From: Planning
Subject: FW: TO UPLOAD 3/2021/0963 PARISH RESPONSE

Consultation on planning application 3/2021/0963 Tanner House Farm, Higher Ramsgreave Road, Ramsgreave BB1 9DJ

Existing Detached Garage Layout Proposed Granny Annex Layout

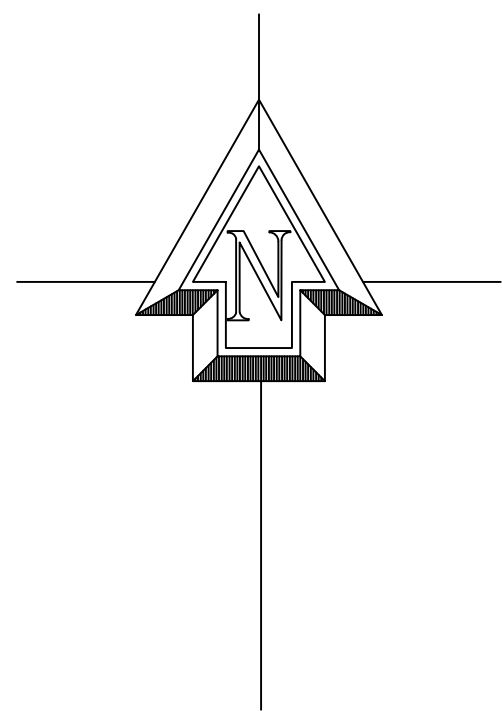
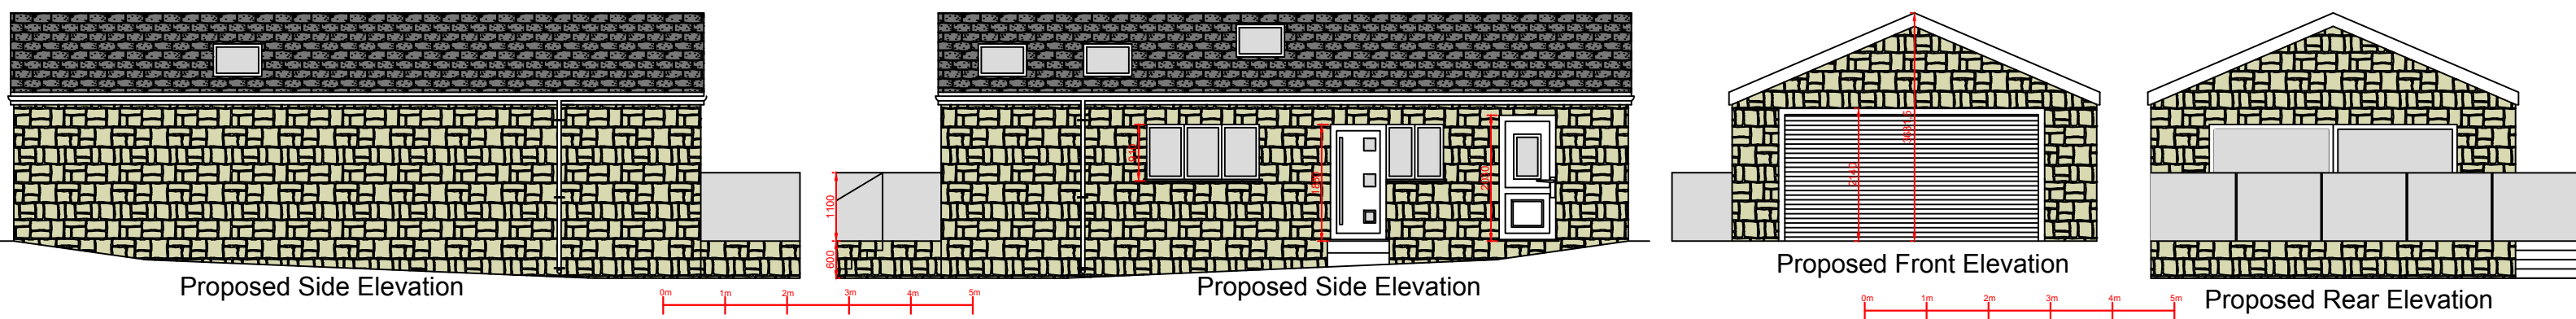
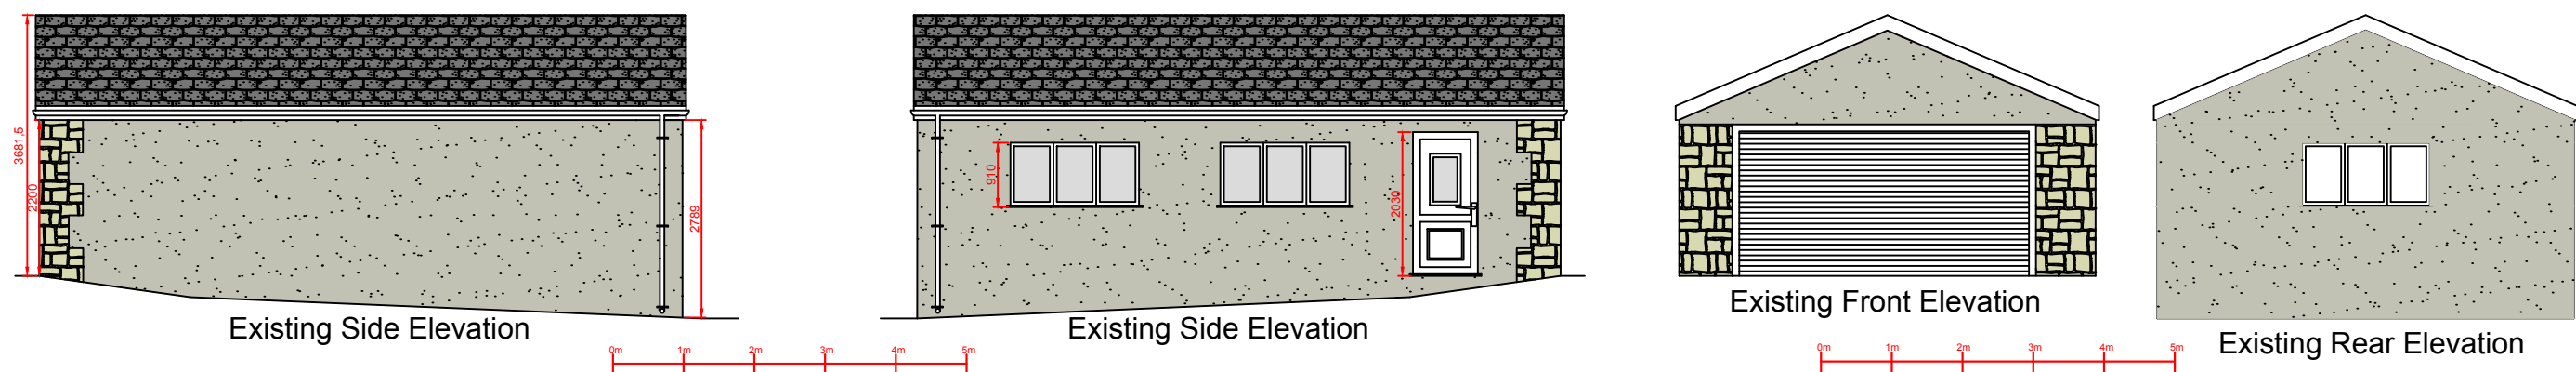
- it is on a 60mph road it is just after a cross roads and parking on the actual road there is extremely dangerous.
- The extension and addition of the granny flat turns the property into a five double bedroom property. There is currently a driveway from the main road which looks to be shared access with the neighbour raising concerns about obstruction here.
- The front of the house has a small enclosed garden, so no room for parking. What allocation, if any, has been given to parking? And therefore, keeping the road free from dangerous parking, as there is no room for parked cars.

The loss of the garage compounds the issues of parking.

CLIENT:	Gail Dunlop	
CONTRACT No:	PCE-Dunlop-September-21	
DATE:	10th September 2021	
SCALE:	1:100, @ A1	
DWG No:	Dunlop-House extension	
L.A:	Ribbles Valley Borough Council	
AMENDMENTS:		DATE:

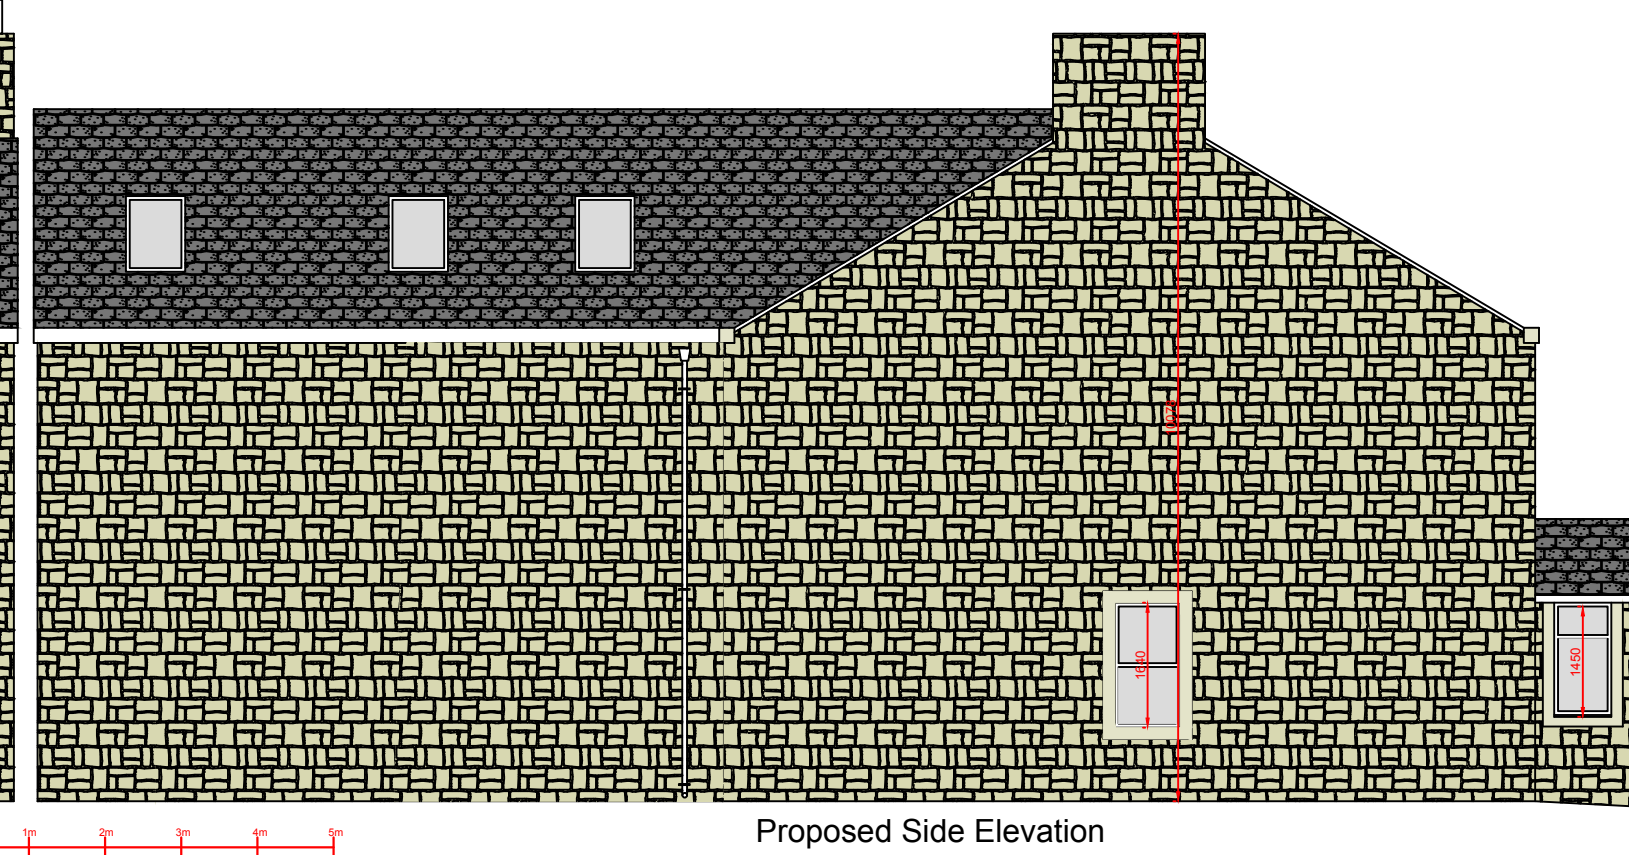
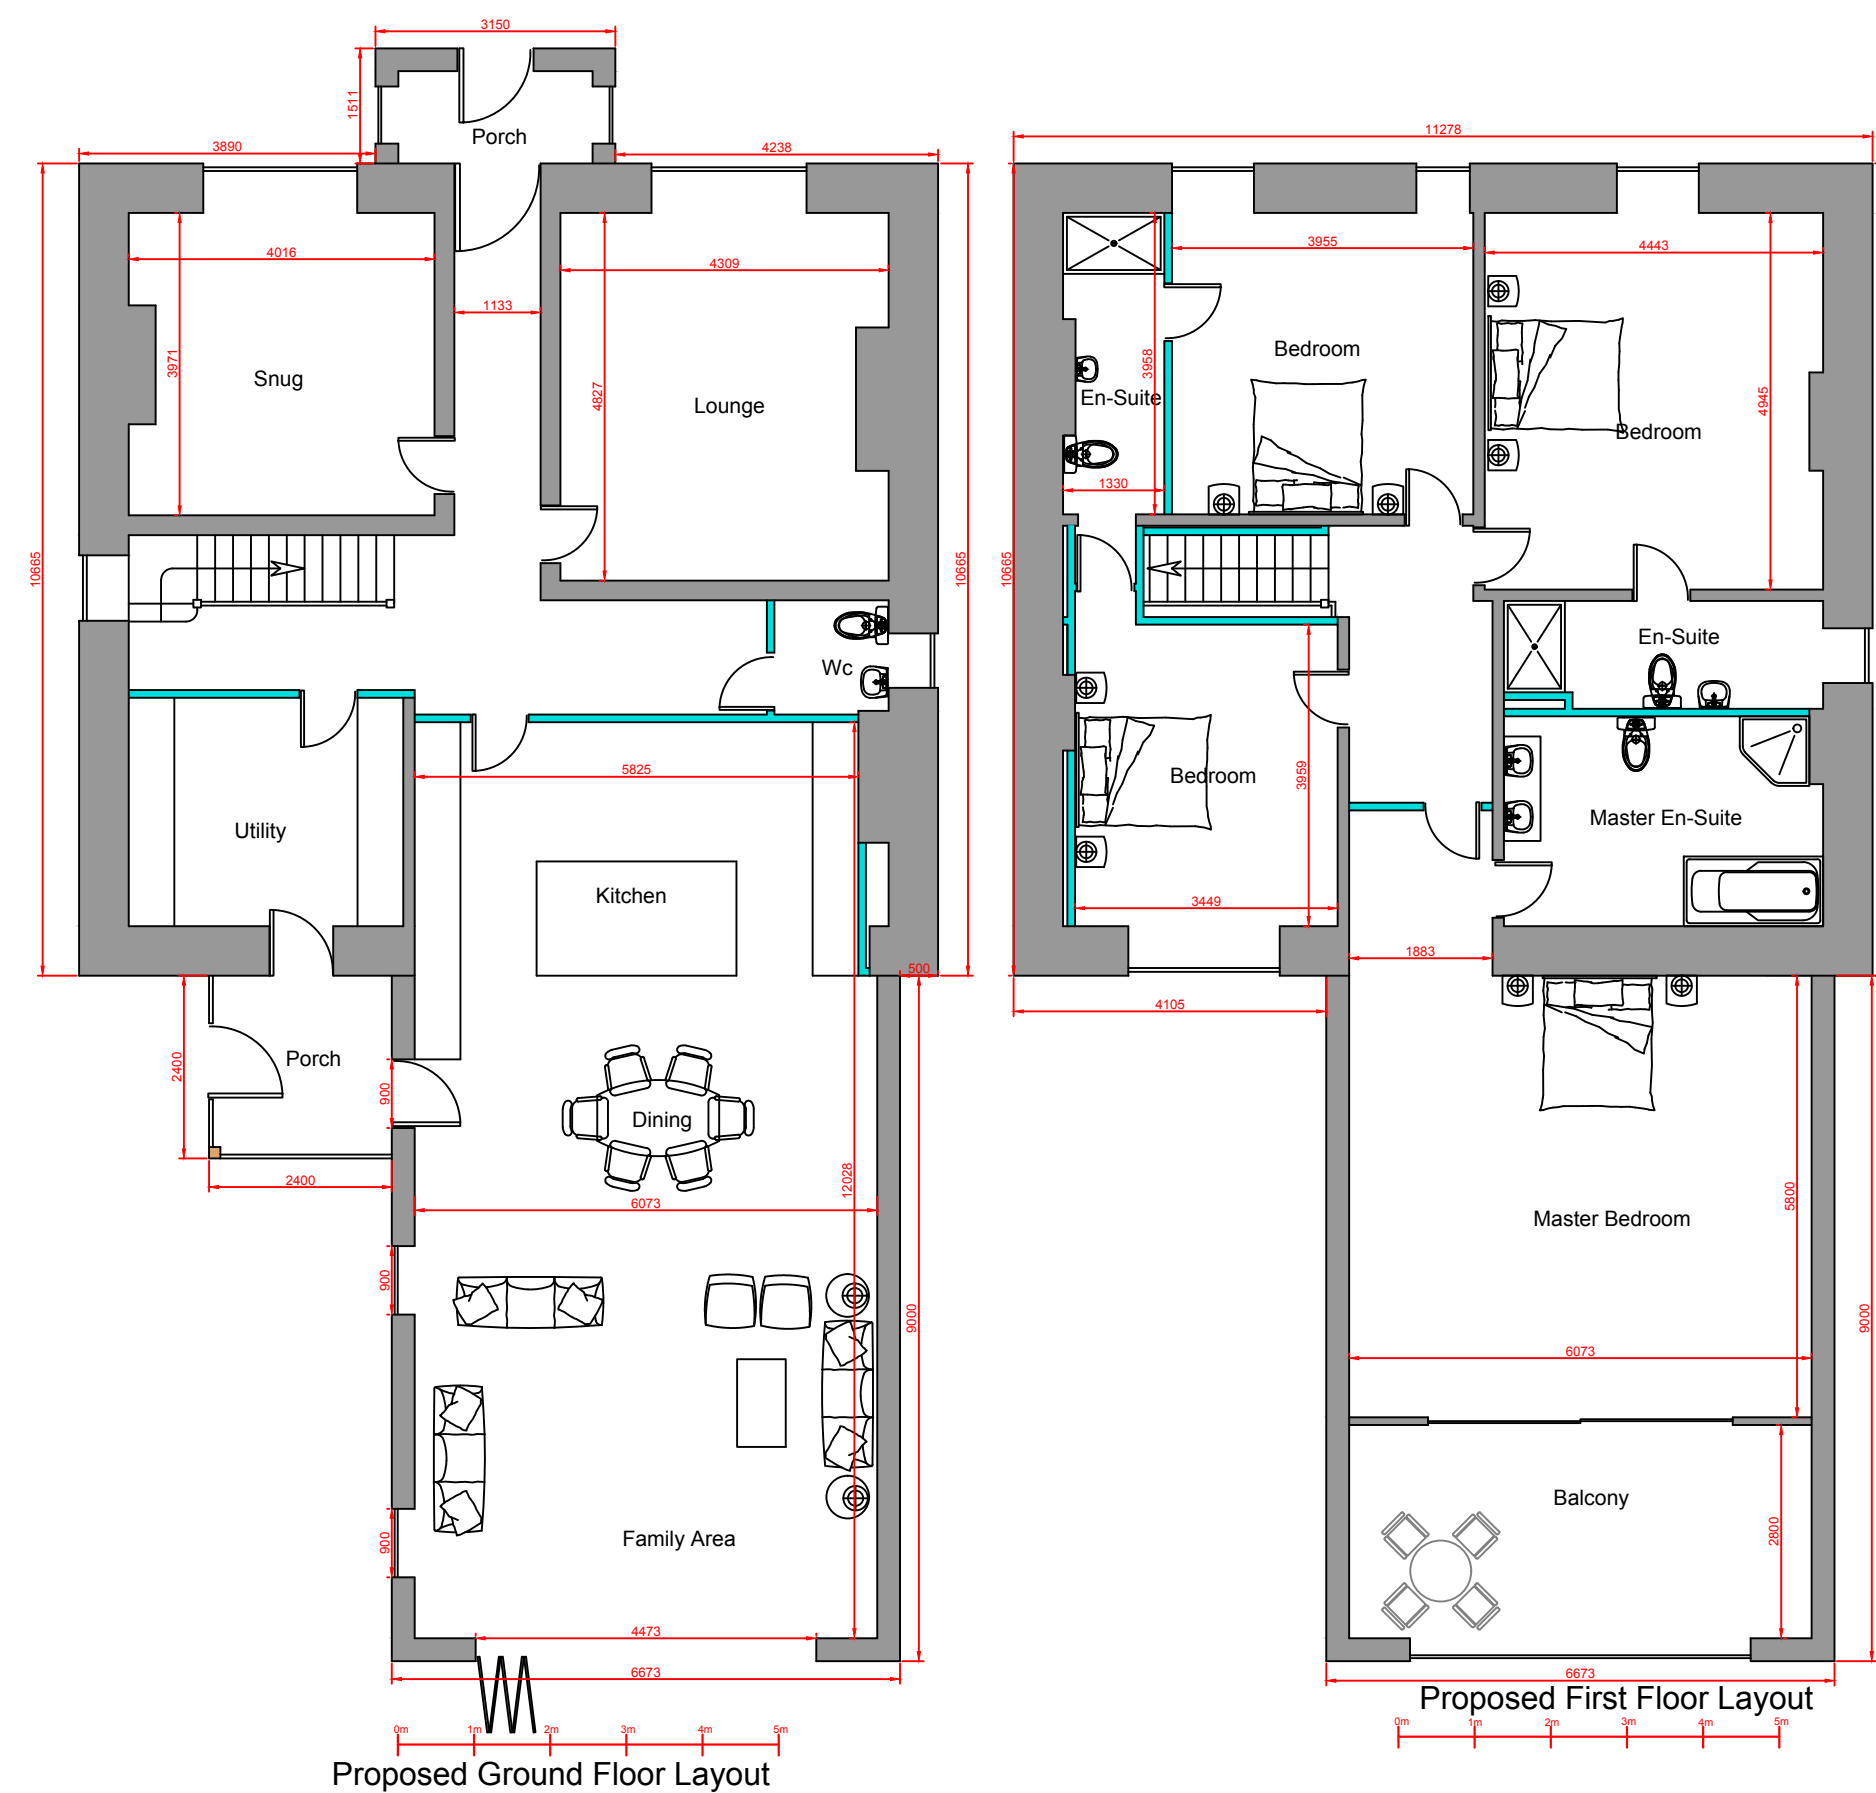
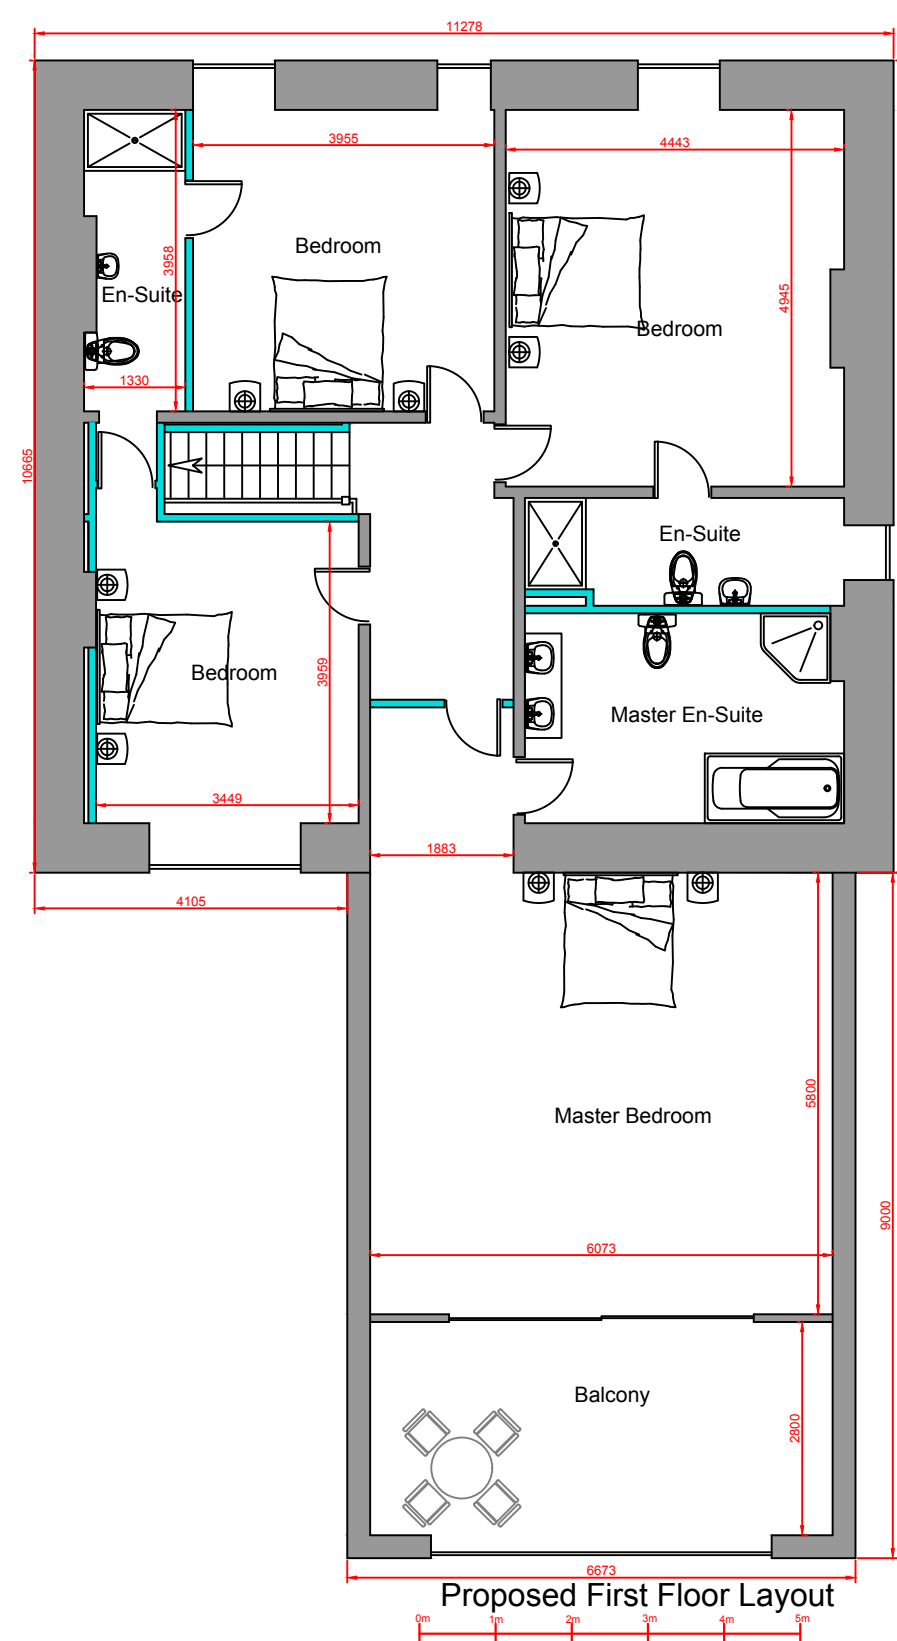
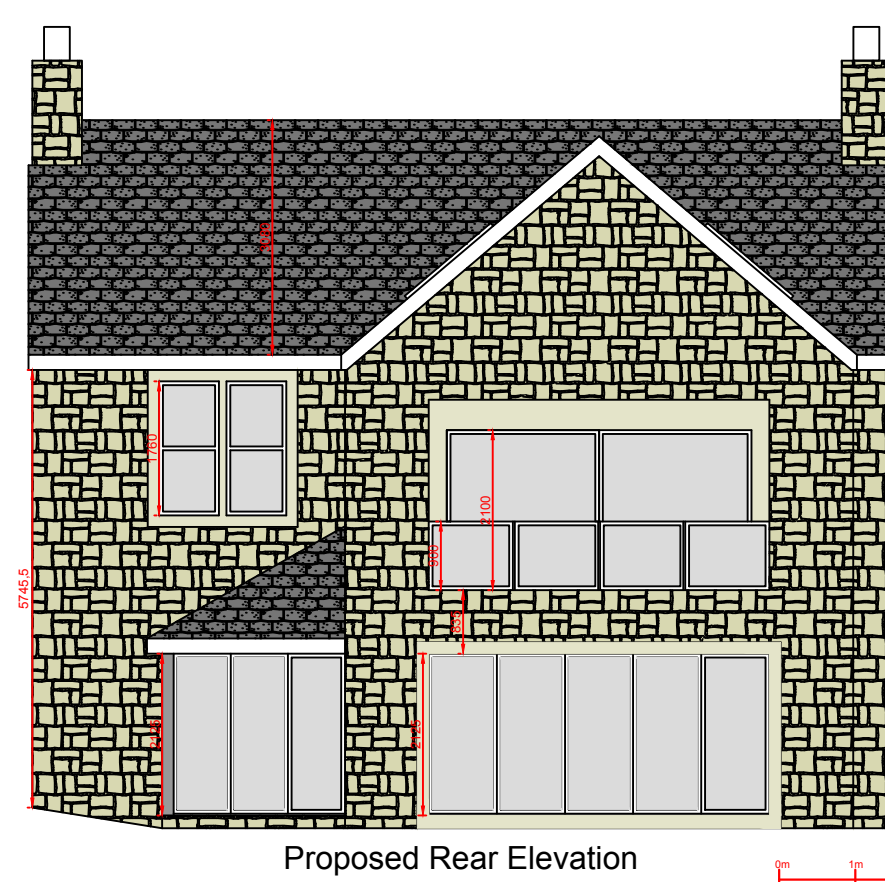
Height of the extension

- the height of the extension on the main house which could potentially block views from neighbouring property and also provide a privacy issue with both neighbours due to the balcony. Going off the plan, the balcony and extension goes quite a distance into the garden.

The size of the extension is too big and not in keeping with neighbouring properties.
